From: Roger Spencer
Sent: 11 October 2017 09:27
To: Planning.Responses
Subject: RE: Planning Consultation on: LU/291/17/PL

NOTIFICATION FROM ARUN DISTRICT COUNCIL
Town & Country Planning Act 1990 (as amended)
Town and Country Planning (Development Management Procedure) (England) Order
2015
Planning Permission
APPLICATION LU/291/17/PL
NO:
Registered: 11th September

Site Address: 2017
Flood defence wall outside 47 River Road Littlehampton BN17
5BZ

Description of Works: Addition of a new segment to the Littlehampton East Bank
Tidal Walls Reach 4 Flood Defences. This application affects
the character & appearance of the Littlehampton River Road
Conservation Area.

SECTION A-A THRU' CAPPING BEAM (TYP.)

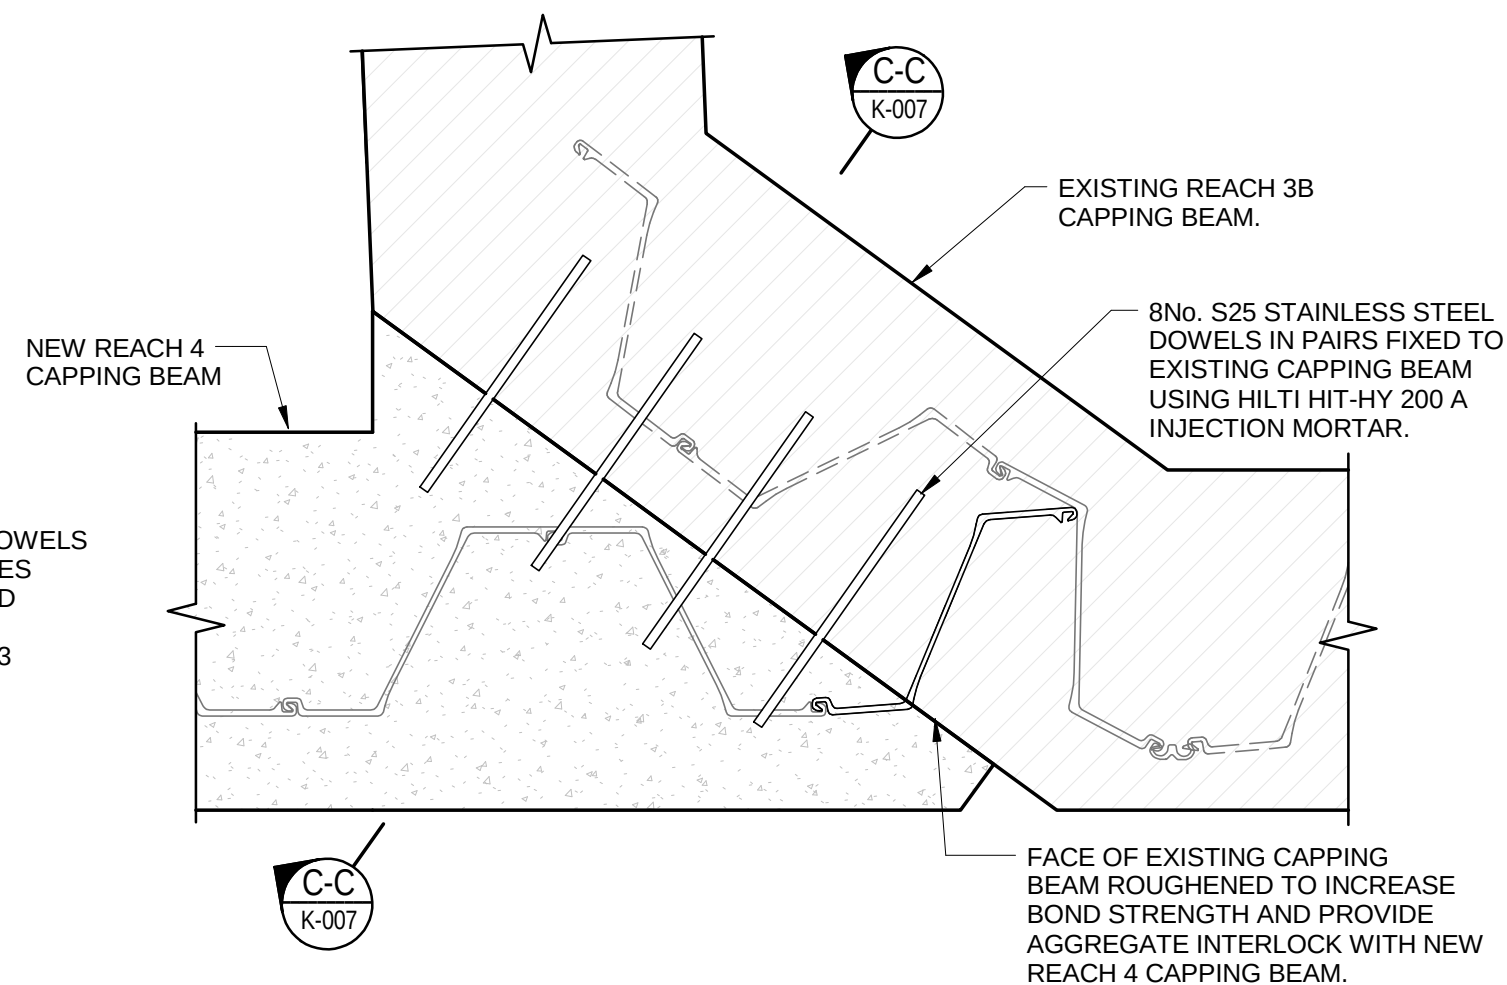
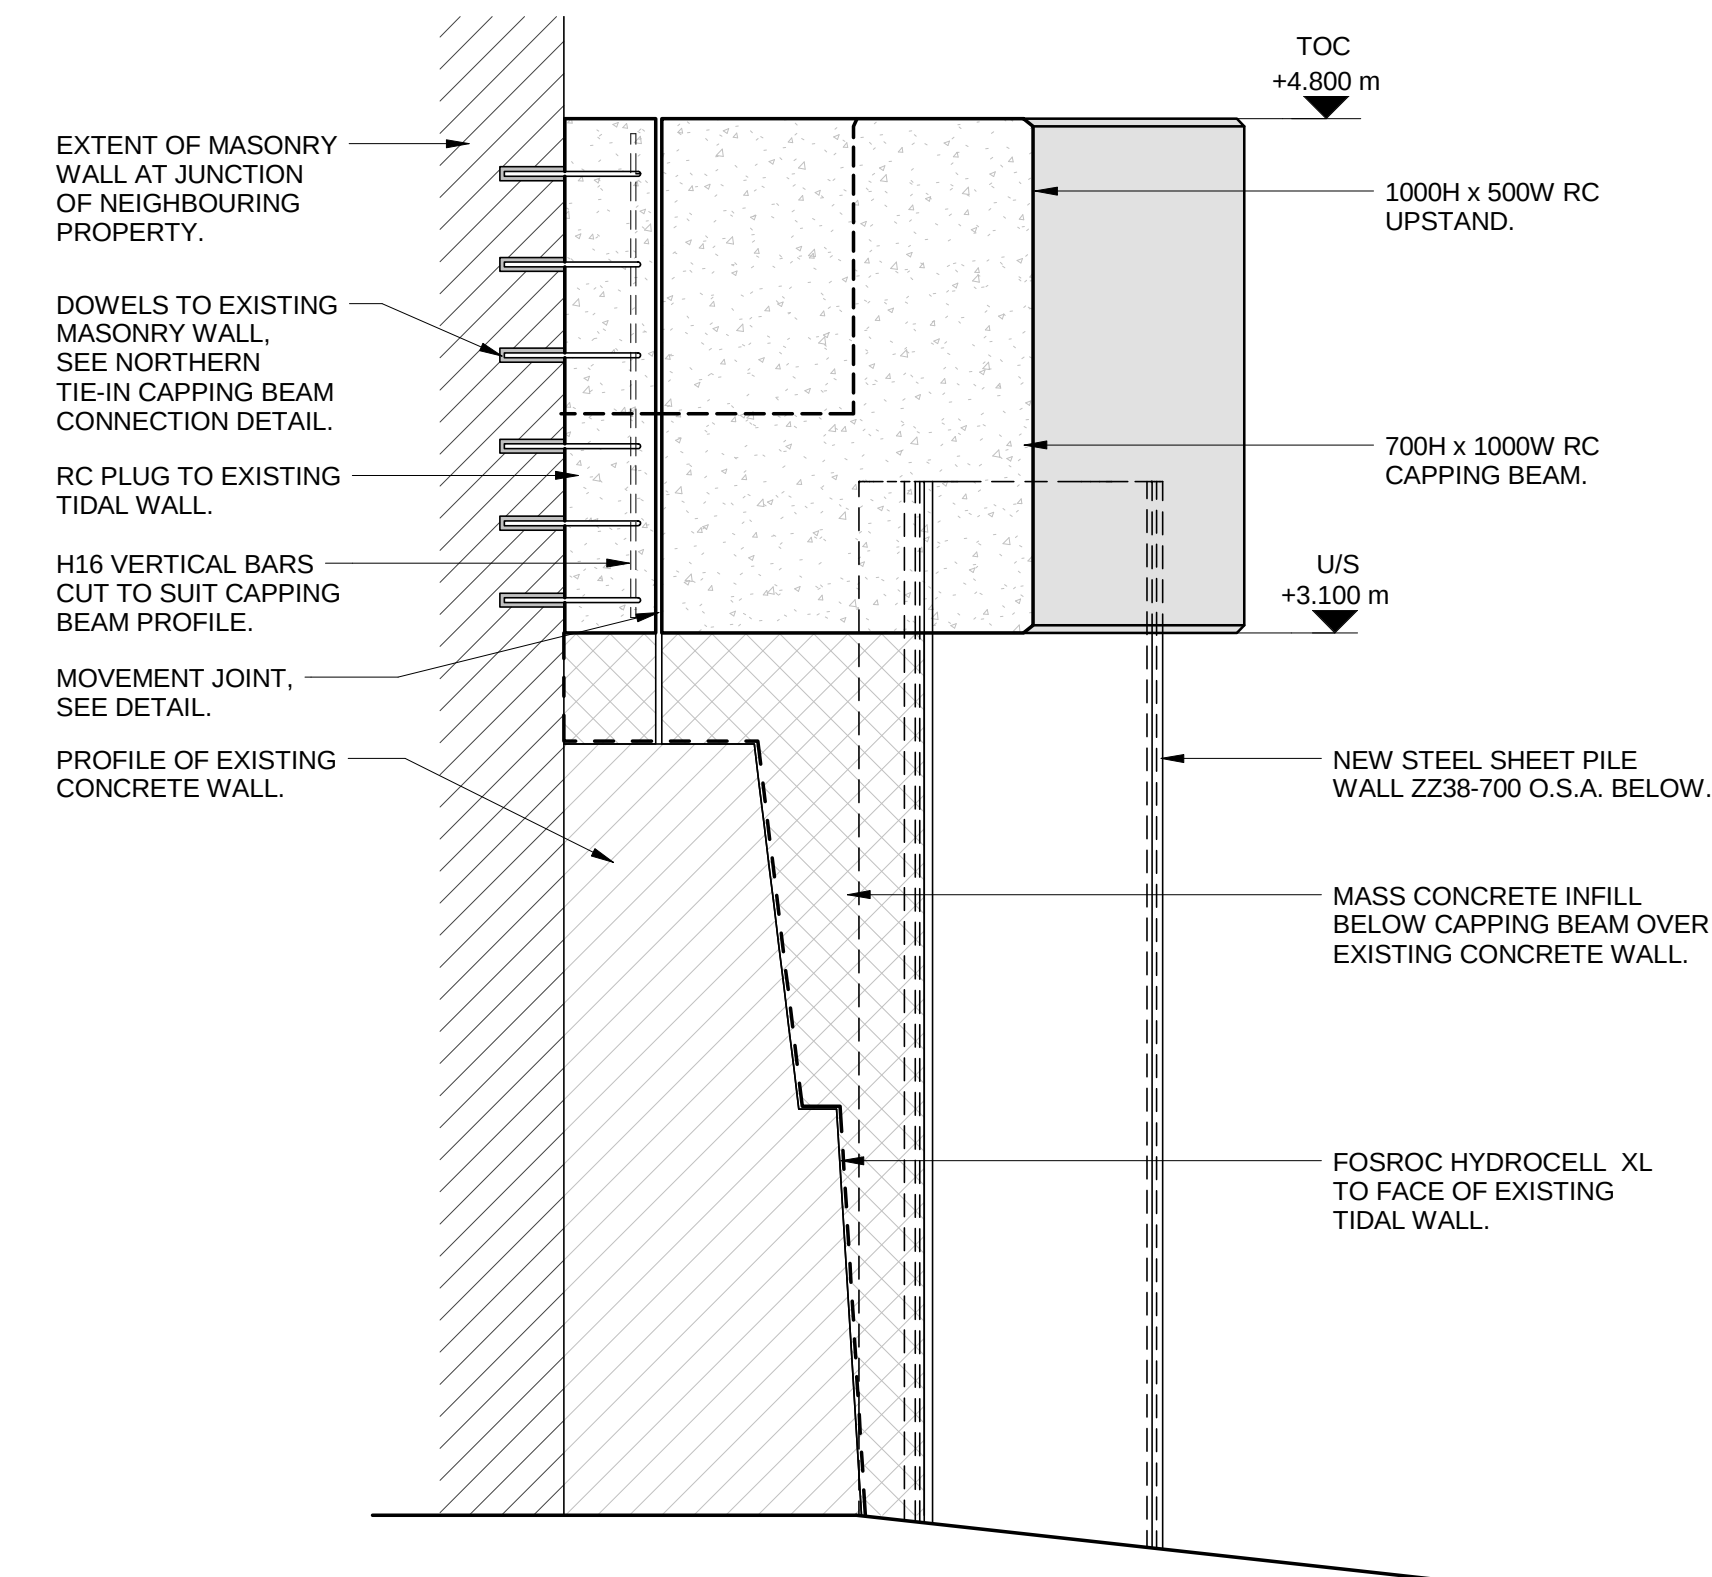
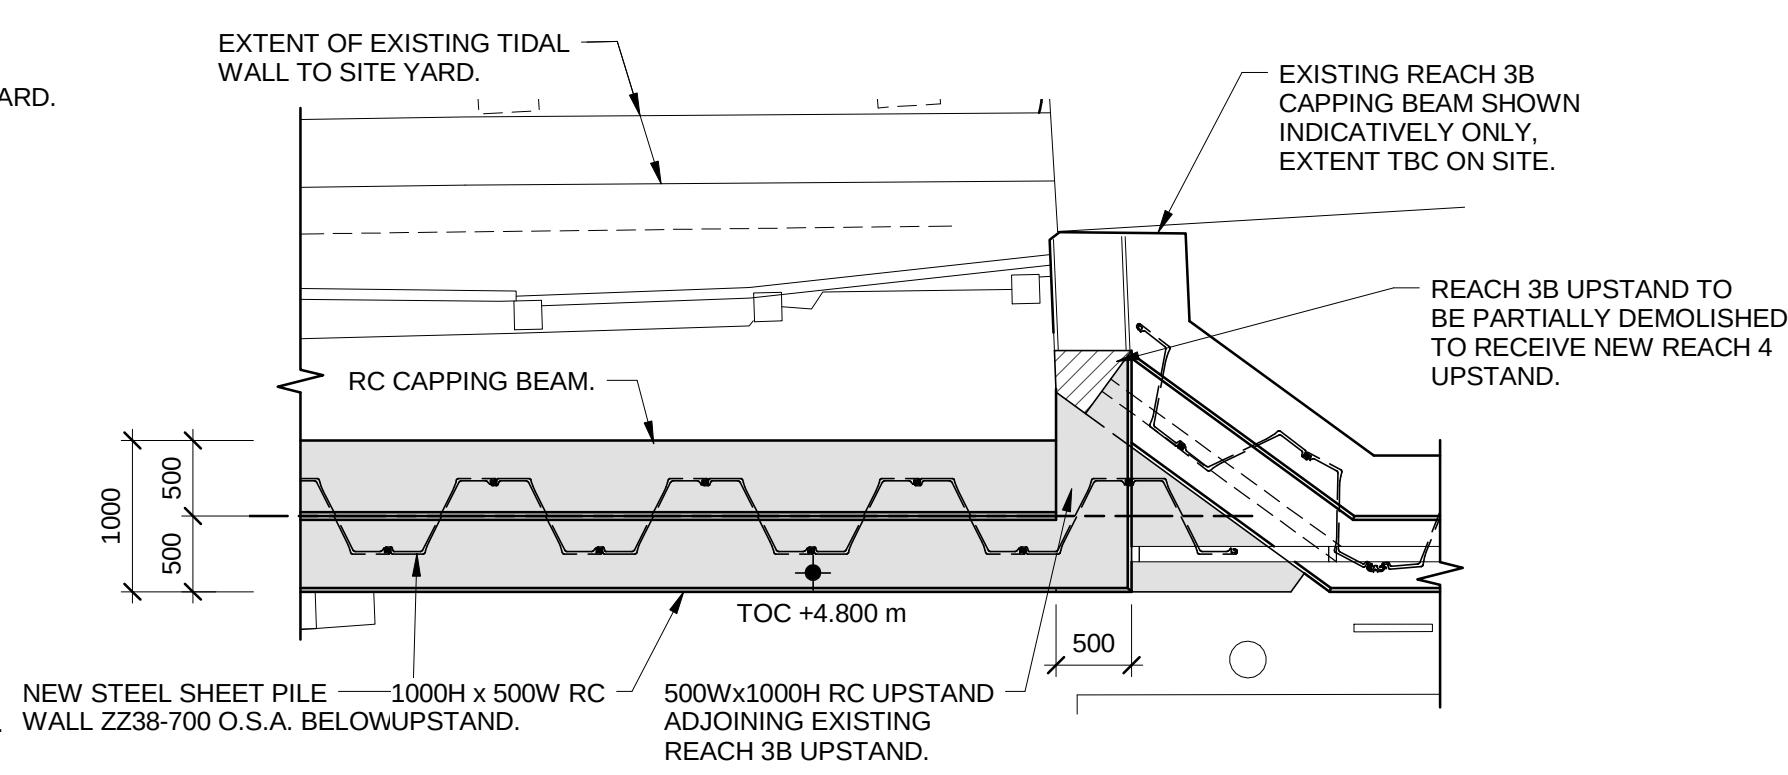
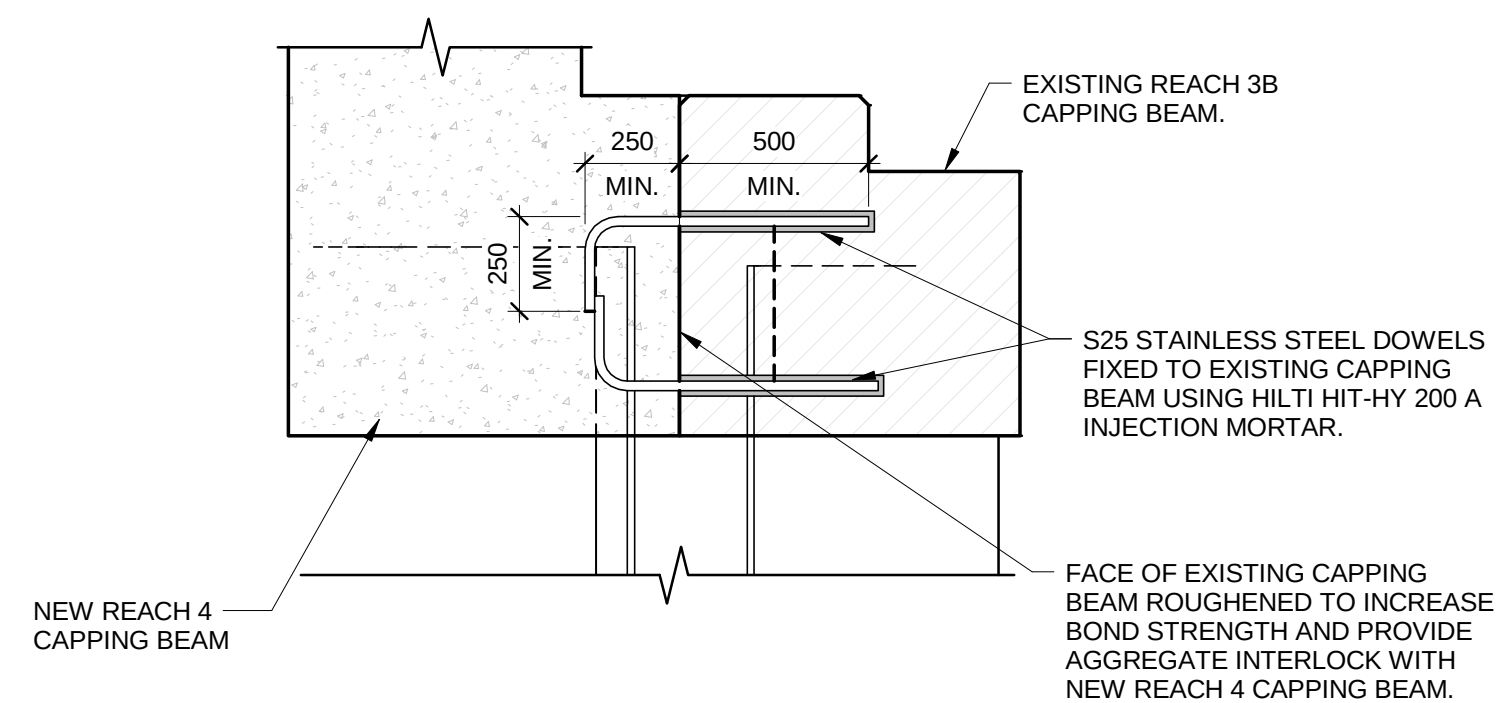
Two matters that may be dealt with as minor amendments in due course are a) the top level of the new wall is to be level at 4.8m AOD and b) the small handrail shown on top of the wall is to be omitted. I have no issues with either of these issues but mention them as points of clarification.
